**Glebe Island Expo**

**Interim Exhibition Facility**

**Glebe Island and White Bay**

**Submission by Leichhardt Council**

CAR PARK LOCATION PLAN
NTS

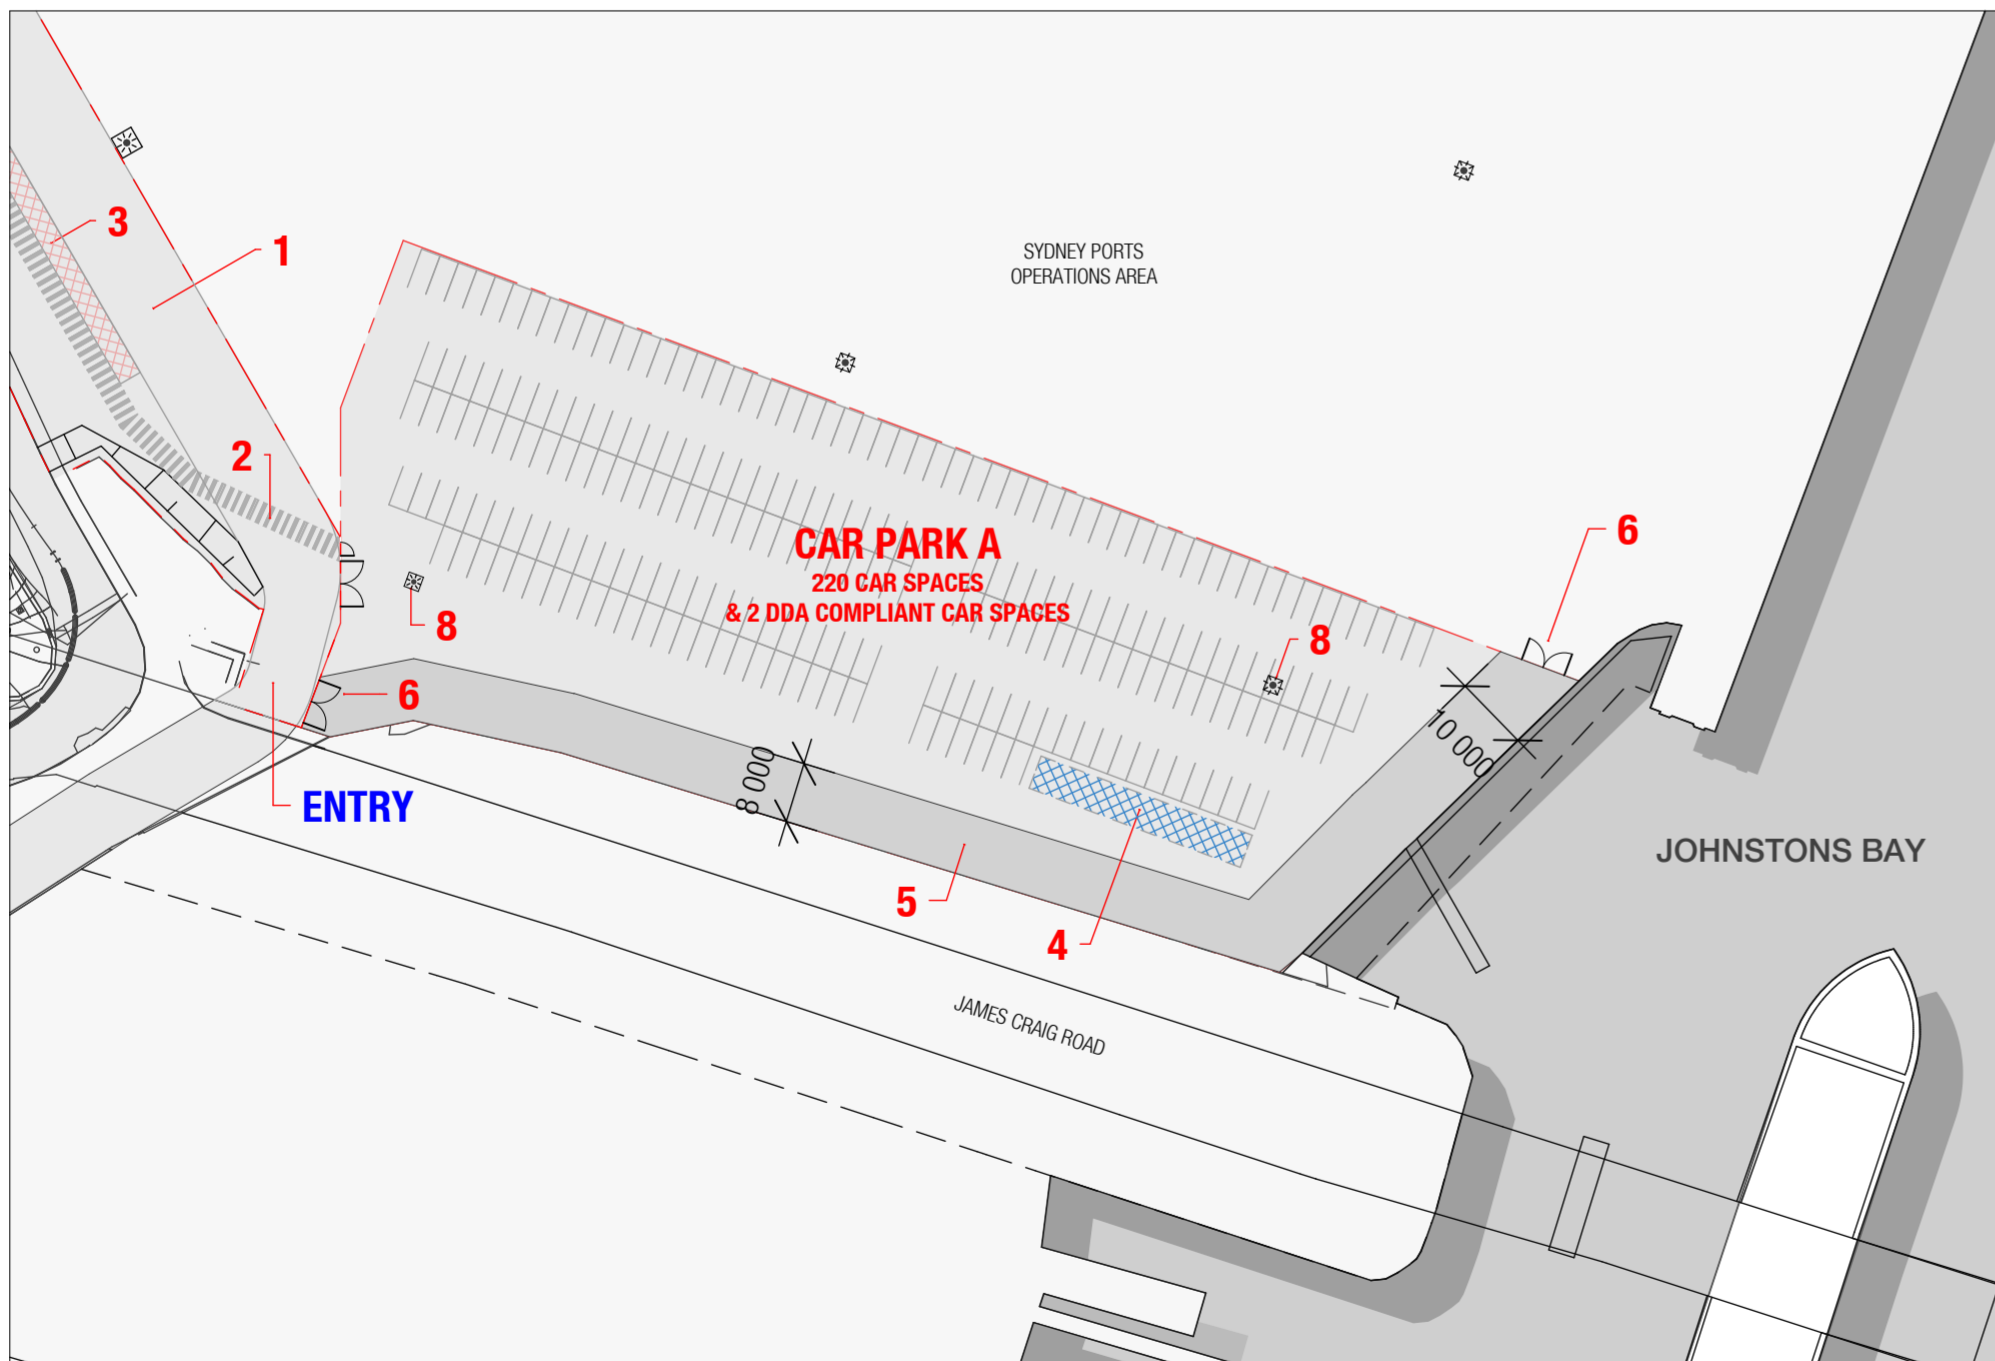
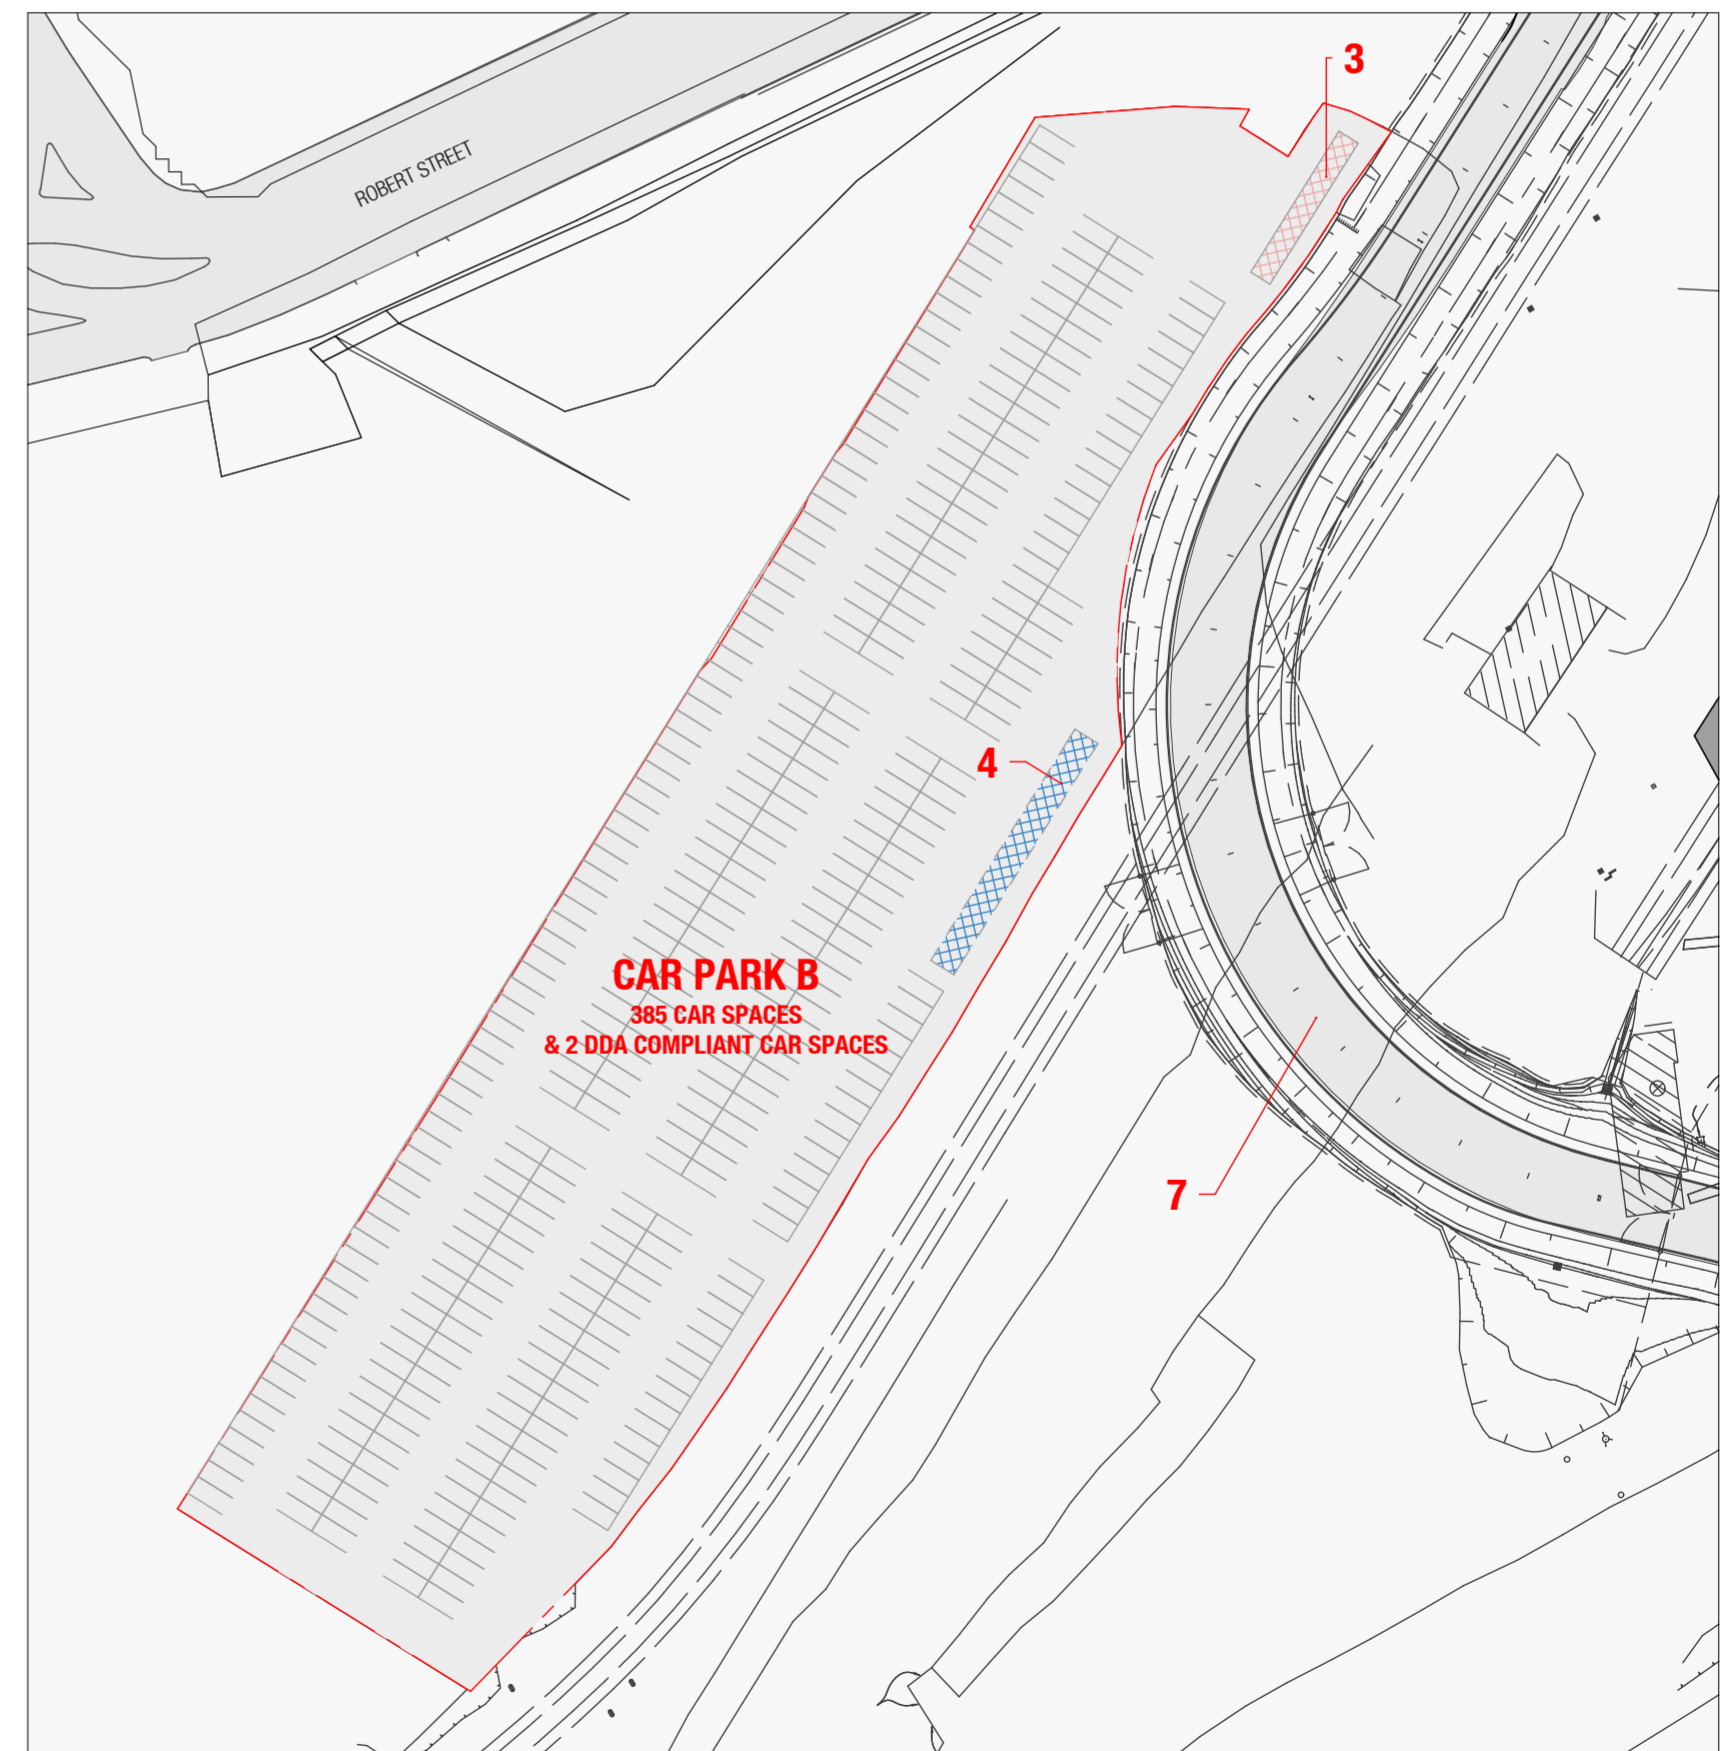
- Deletion of the proposed road link between the Glebe Island site and Robert Street Rozelle in order to avoid unacceptable impacts on the local traffic network, key intersections and the existing street parking

- The exclusive use of James Craig Road for all vehicular access and egress to the facility, including all car parking and delivery vehicles
- Further analysis of the transport, traffic and car parking impacts of the development and update of transport and traffic management plans in response
